**WEST SUSSEX COUNTY COUNCIL
STRATEGIC PLANNING CONSULTATION**

SUBJECT: FG/136/14/PL -Amendments to ground floor layout including replacement WC's and new staircase to 1st floor (20sq.m), new layout and staircase to existing 1st floor store, layout to include; offices, meeting room, WC and staffroom (215sq.m), new 60no space car park adjacent to Country Centre (2950sq.m), new bitumen surface construction to section of existing pedestrian path (176.5sq.m).

Ferring Country Centre, Rife Way, Ferring, West Sussex, BN12 5JZ

DRAWING TITLE:
PLANNING
Proposed Site Plan (Inc.
Car Park and New Path).

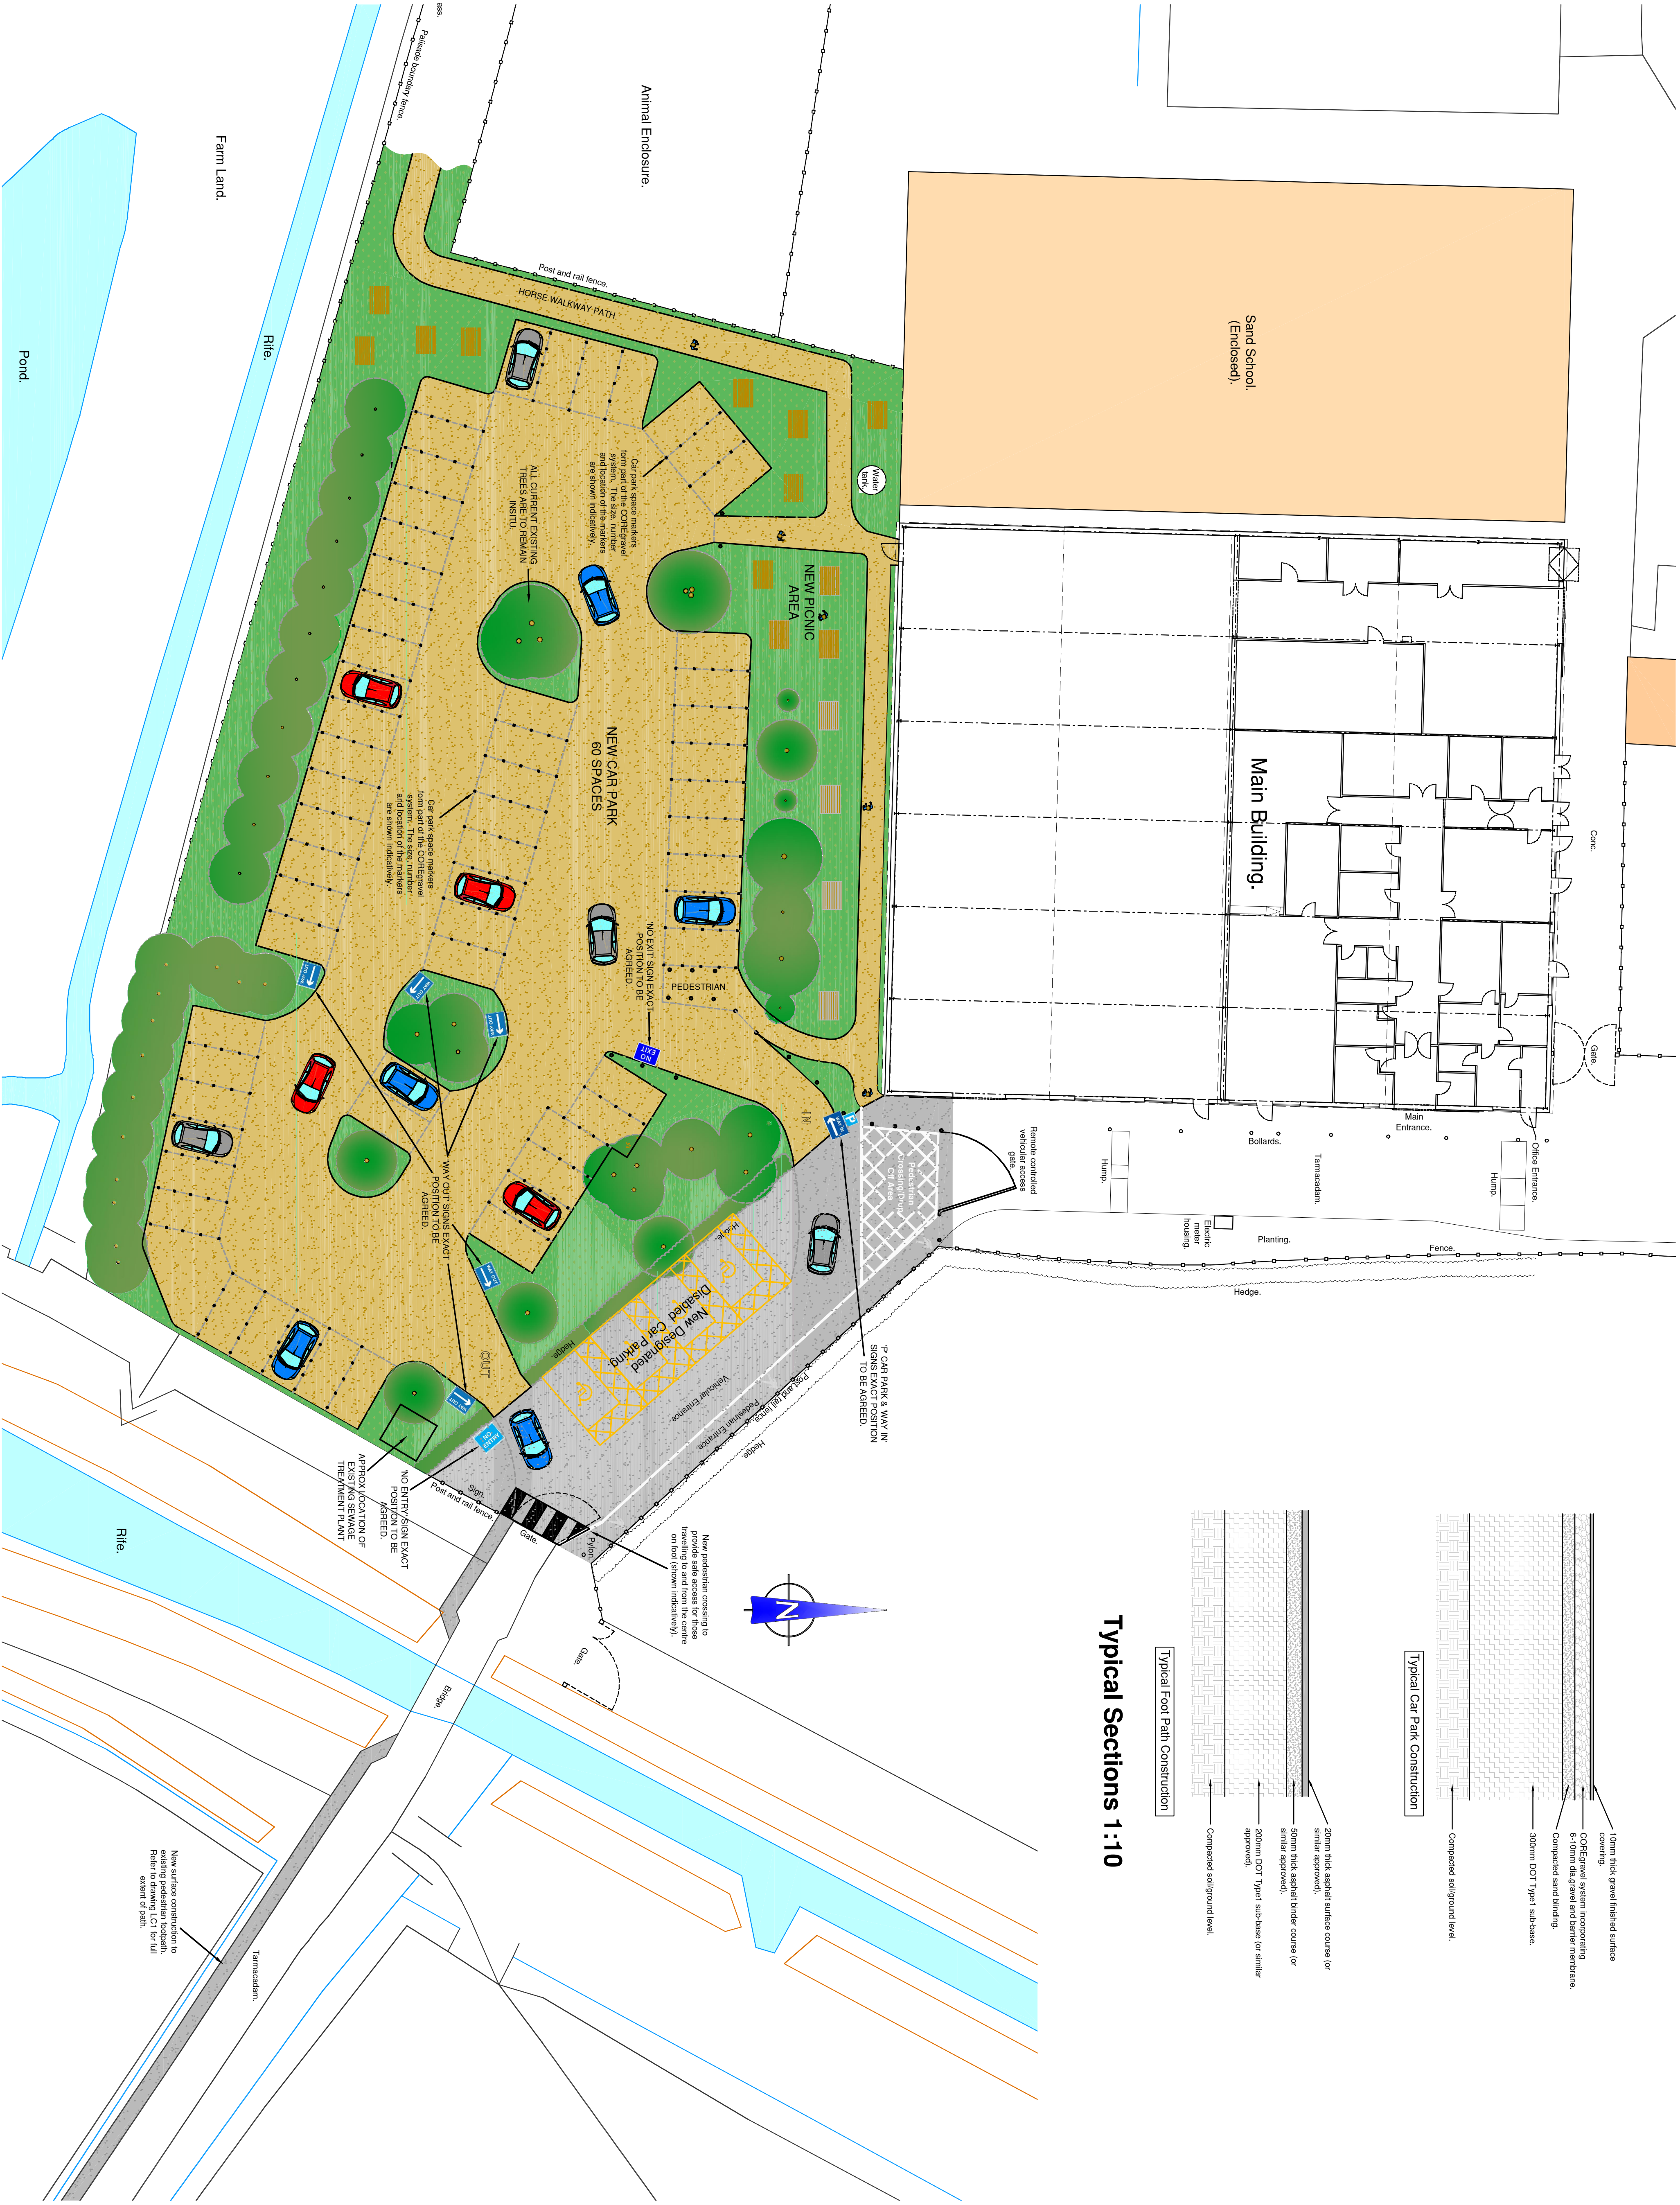
The Community Centre has seen an increase in parking volumes in the last 24 months which this proposal seeks to address this with additional parking areas. Based on the submitted information there would be no concerns with this proposal. The internal layout of the proposed parking area is considered acceptable. There are signs directing traffic around the parking area and the in/out arrangement has been clearly shown. The proposed parking spaces should be 2.4 by 4.8 metres in width with disabled spaces 3.3 by 4.8 metres. There is sufficient turning area for vehicles to manoeuvre within the car park.

Matters relating to access during the clearing of the land and construction of the proposed would need to be agreed prior to any works commencing. Vehicular access to the site is

possible only from Rife Way. A comprehensive construction management plan should be submitted. This should set out the controls to be implemented throughout the construction project to ensure that safety of users of the public highway, as well as its operation, is not detrimentally affected. The construction management plan should amongst other things set out how deliveries are to be managed along Rife Way in light of the carriageway width and presence of other vulnerable road users.
